Rezoning Transportation Analysis

Petition Number: 2020-133

Date	Description
10/20/2020	First Review (KP)

Conceptual Site Plan

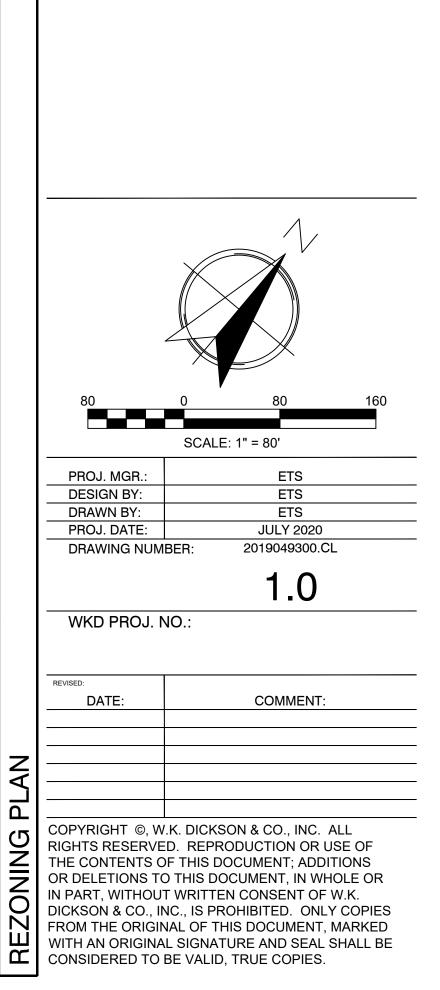
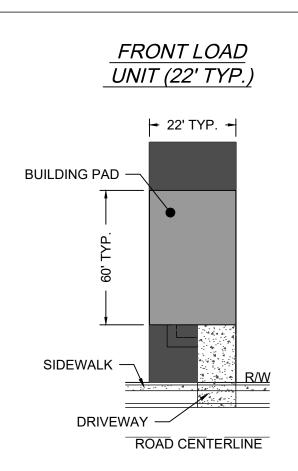
- Label and dimension the curb line, as depicted on the site plan, from the centerline of Hamilton Road to the proposed back of curb.
- Traffic Study** A Traffic Impact Study is not necessary for the complete review of this petition. If during the permitting process the site generates more than 2,500 daily trips, then a traffic study will be required.

- Label and dimension the proposed right-of-way, along Hamilton Road, from the Hamilton Road centerline, including the commitment to dedicate the proposed right-of-way in the conditional notes.

- Label and dimension the proposed planting strip and the 12-foot multi-use path from the centerline of Hamilton Road, including the commitment to the construction of the proposed planting strip and 12-foot multi-use path in the conditional notes.

- Revise the site plan by providing a street stub, instead of a cul-de-sac, at the terminus of Public Road B.

- Add a conditional note stating the left turn-lane, tapers, and median striping, at the intersection of Hamilton Road and Public Road A, will be designed accordingly to NCDOT Standards.

- Revise the site plan and the conditional notes to commit to the construction of the three-lane cross section along this site's frontage on Hamilton Road, to the western Hamilton Road terminus of the

8. Revise the site plan and the conditional notes to commit to constructing a southbound right-turn lane, on Steele Creek Road, onto Winged Teal Road. Include in the conditional notes that this right-turn lane construction will be coordinated with NCDOT during the permitting process.

9. Revise the site plan and the conditional notes to commit to the construction of a southbound left-turn lane on Youngblood Road, to turn on Hamilton Road, with 150-feet of storage. Include in the conditional notes that this left-turn lane construction will be coordinated with NCDOT during the permitting process.

10. Revise the site plan by designing the development with the appropriate block length(s), as described in Chapter 20 of the Subdivisions Ordinance.
